Rio Grande Credit Union

Administrative Amendment Request

Project #PR- 2020-003561

Transportation Development Comments:

A101

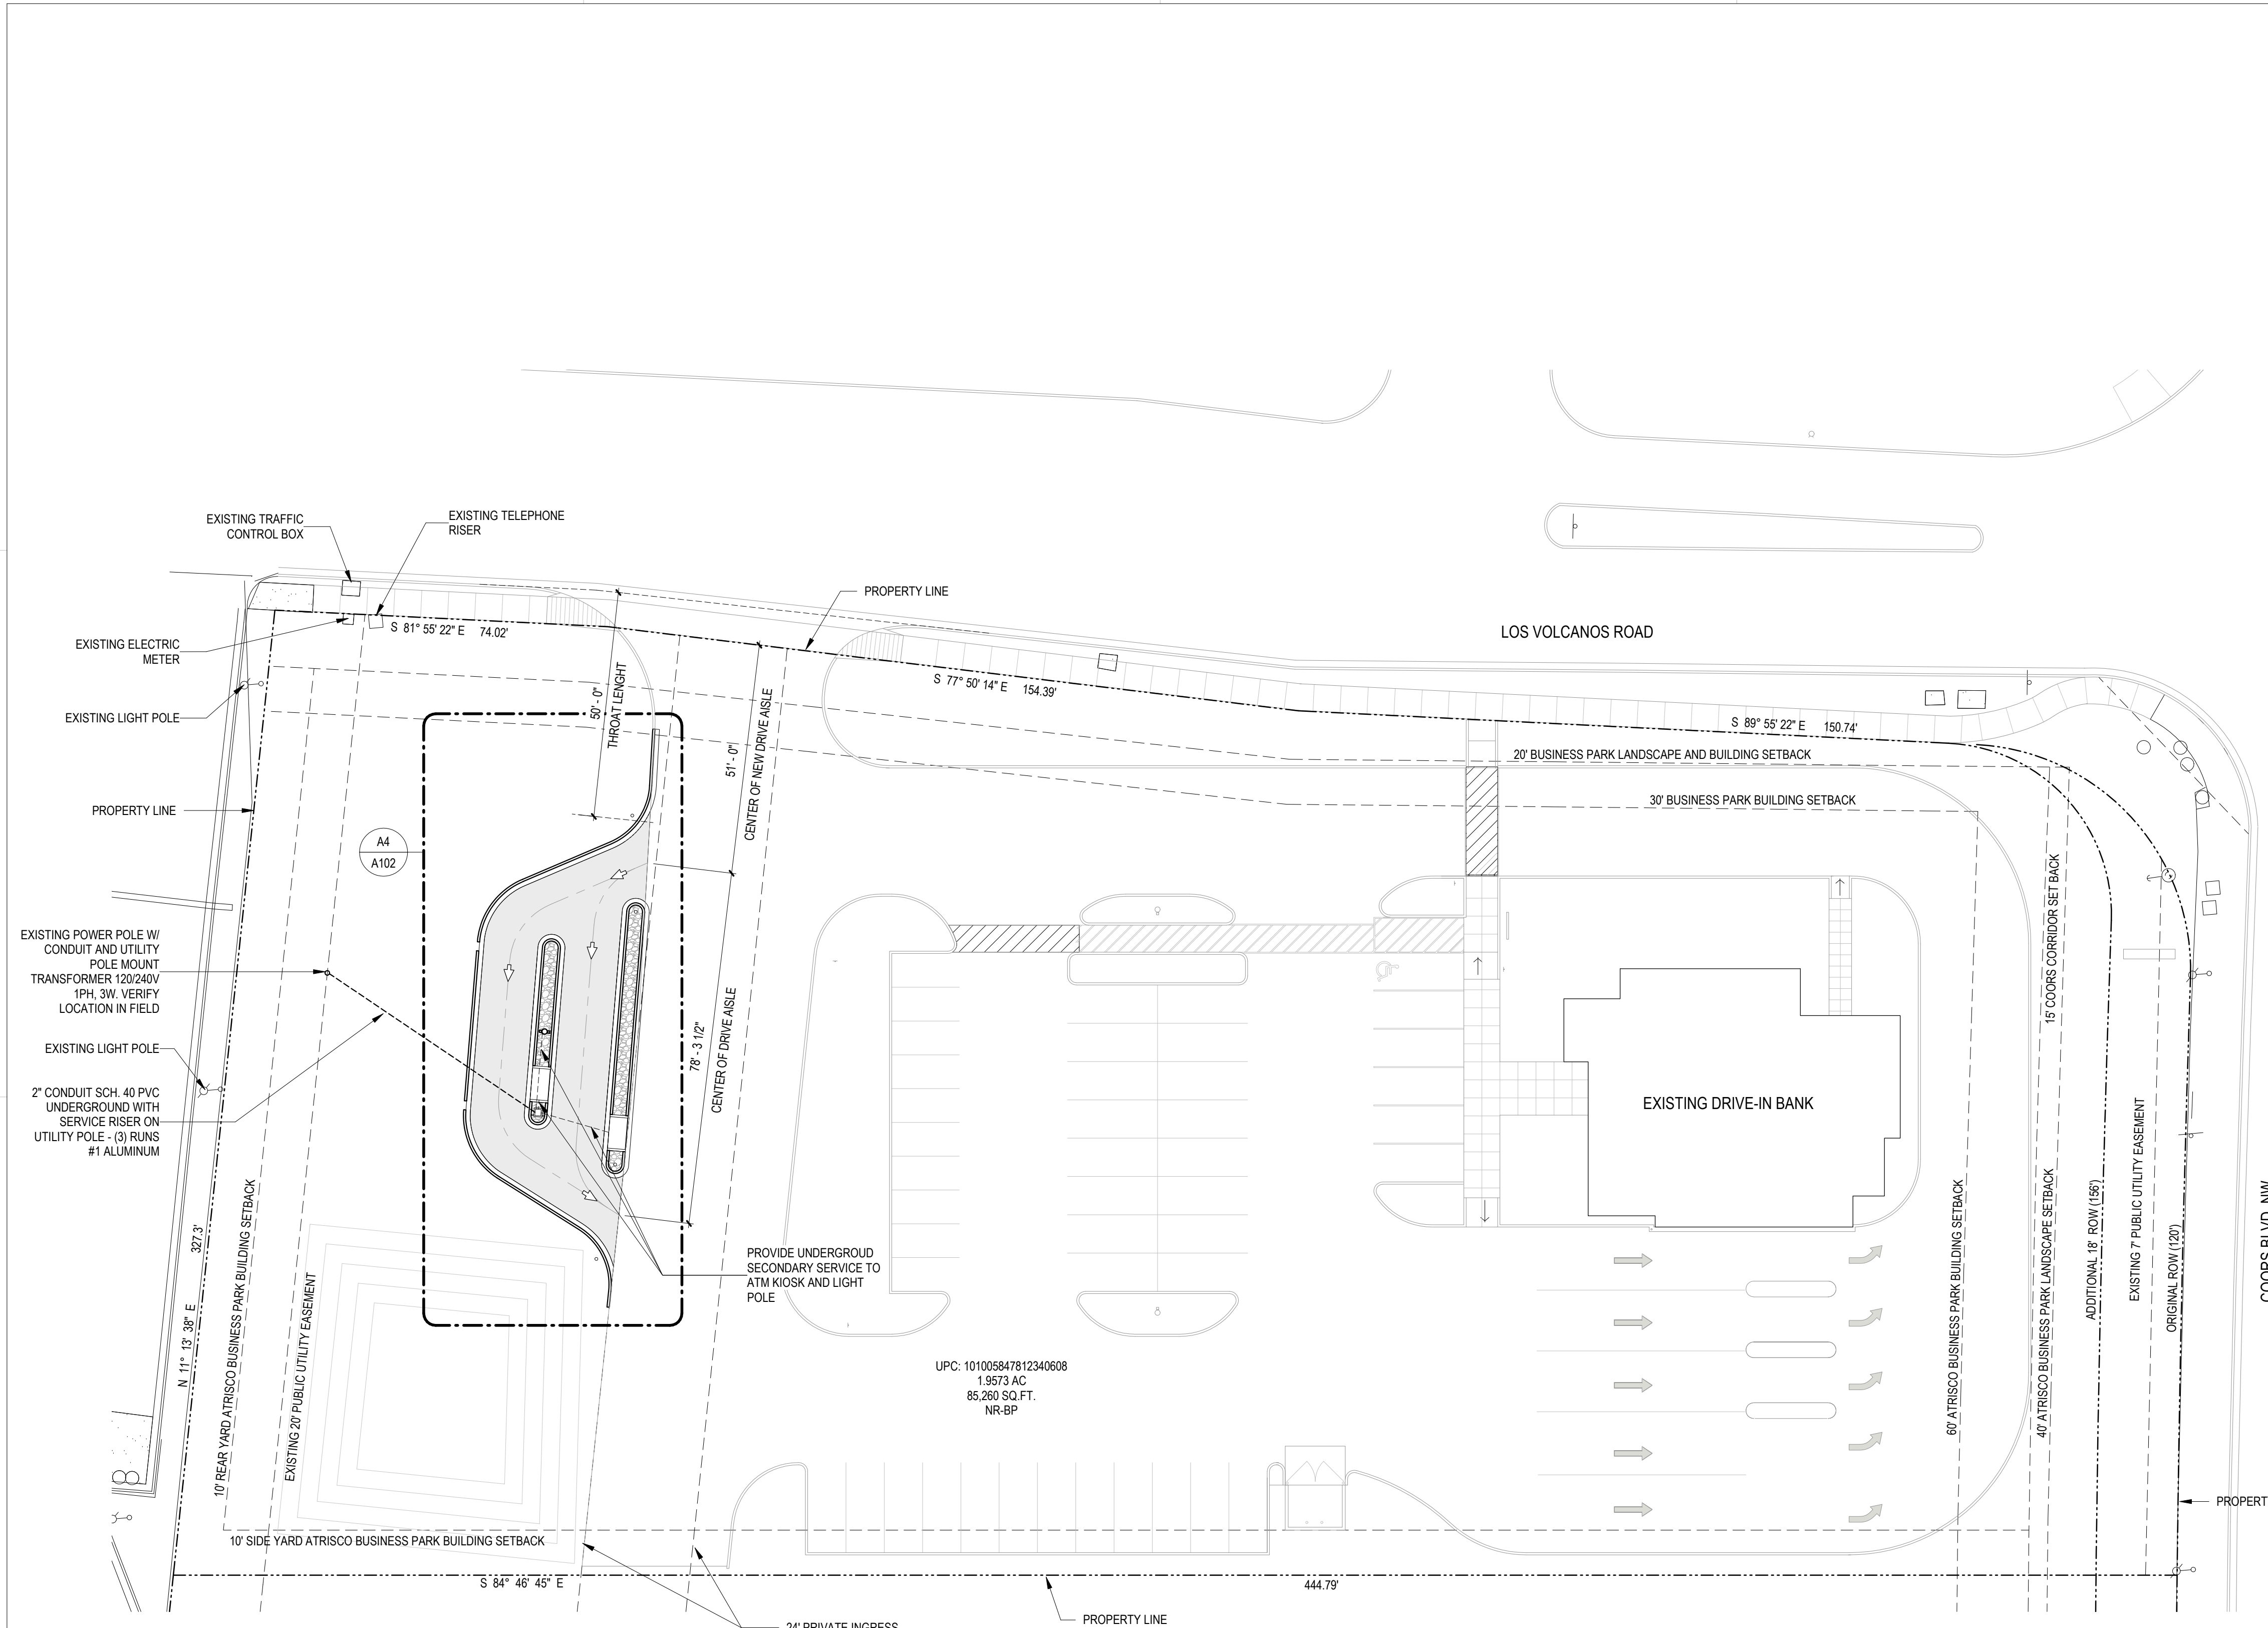
- Clarify the intent of the proposed paper easement referenced. On the plan, it shows that it is a proposed private access and drainage easement, and on the keyed note, it shows that it is public right-of-way. If an access and drainage easement is to be established as shown on the plan, it shall be in place prior to Transportation and Hydrology approval; a public utility easement that is established has to go through utility companies prior to approval from Russell Brito of Planning.

- There is a stray keyed note 45 south of the exit of the drive-thru.

A102

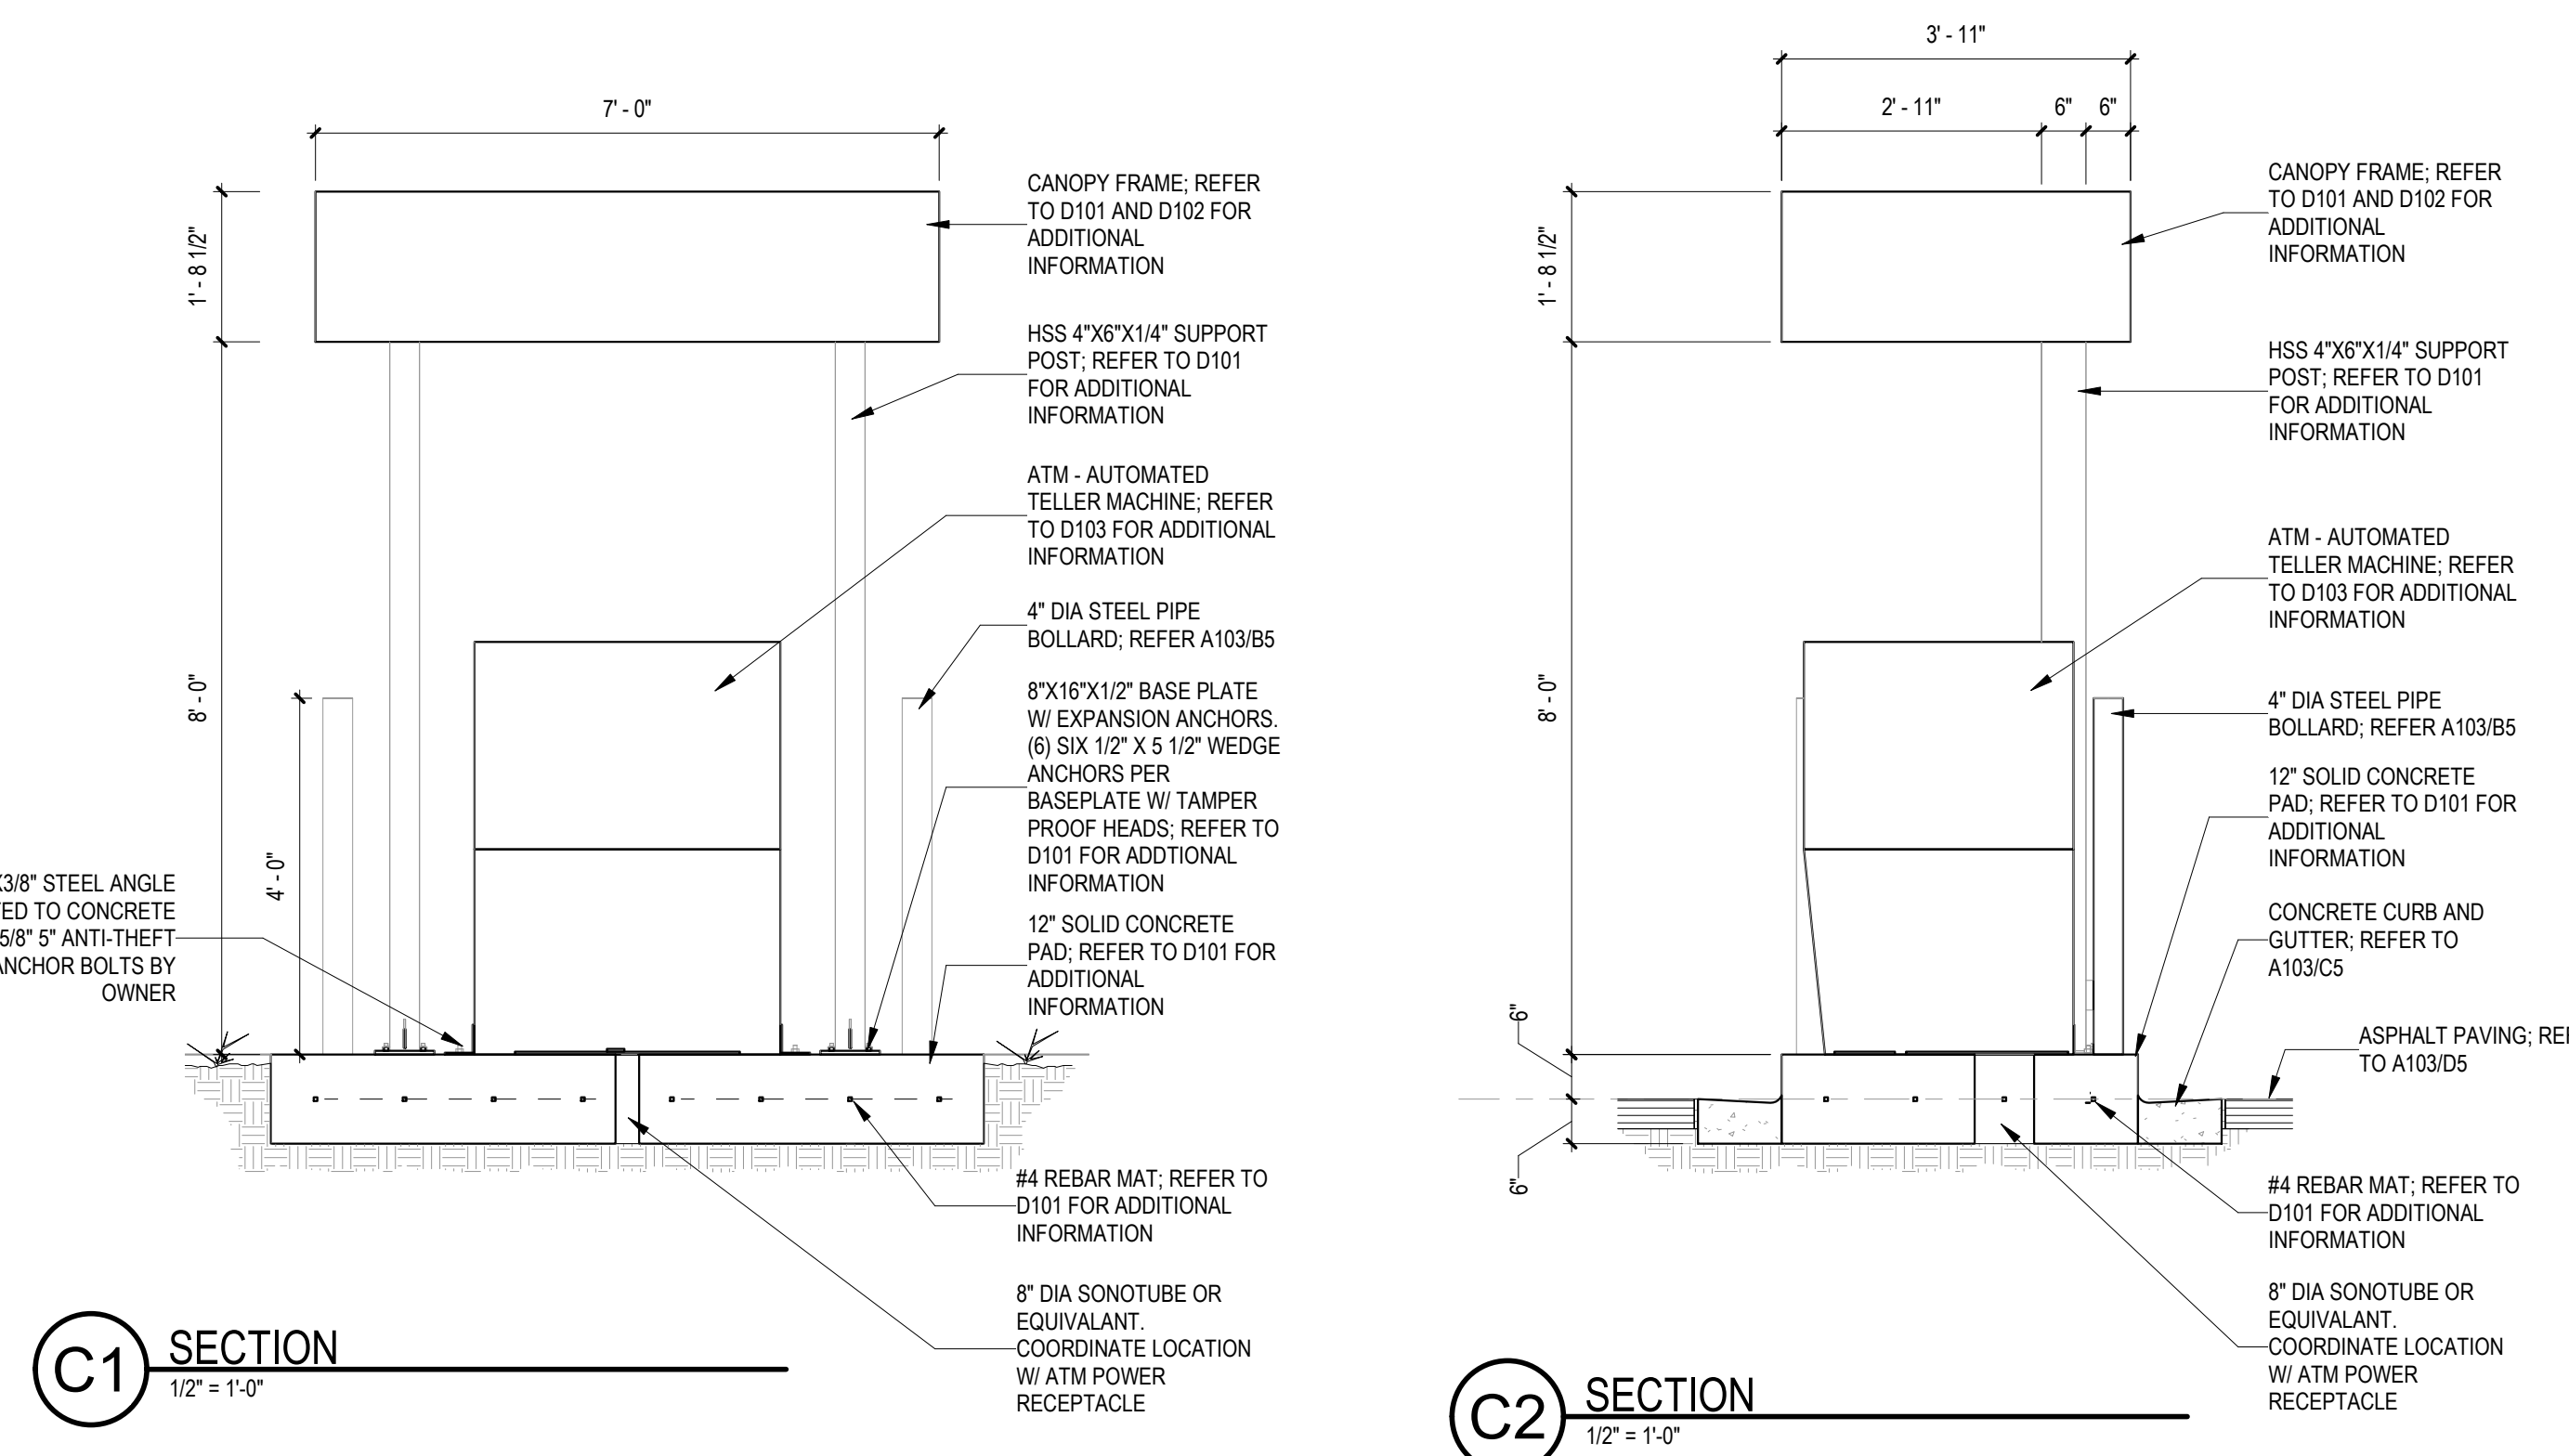
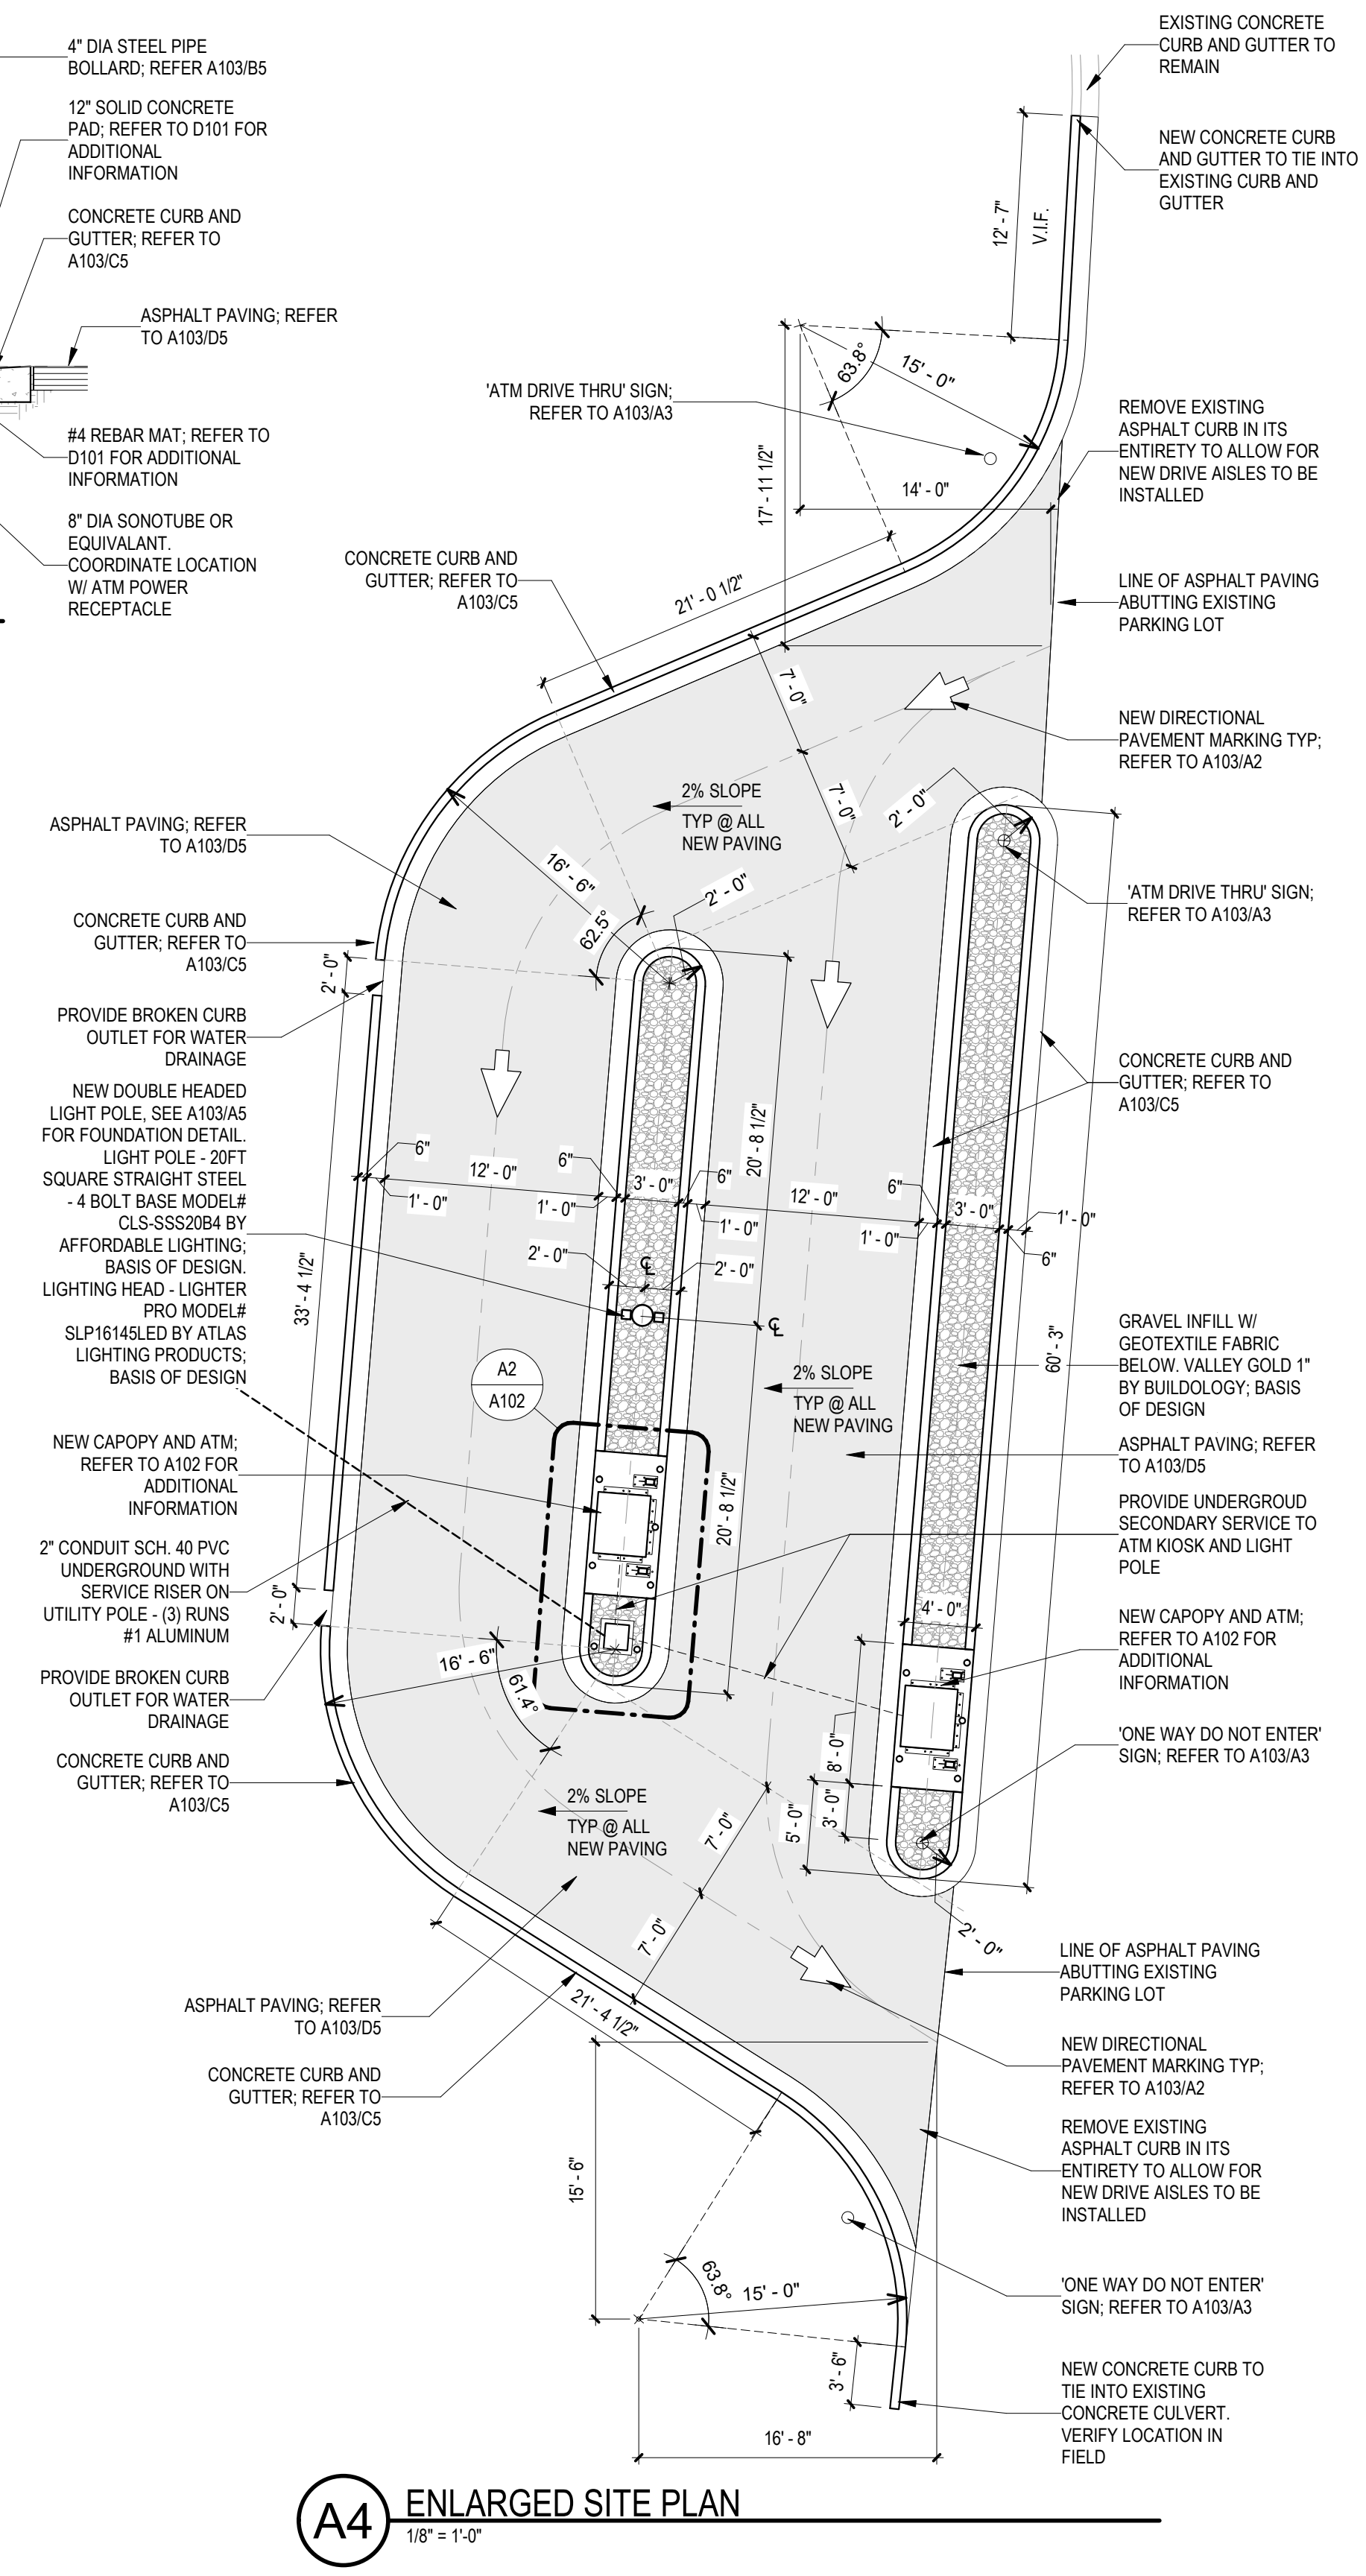
- On Sheet A102, based on dimensions provided, the bollards and adjacent equipment appear to be in conflict with the proposed curb and gutter. Modify dimensioning as needed to eliminate the conflict.
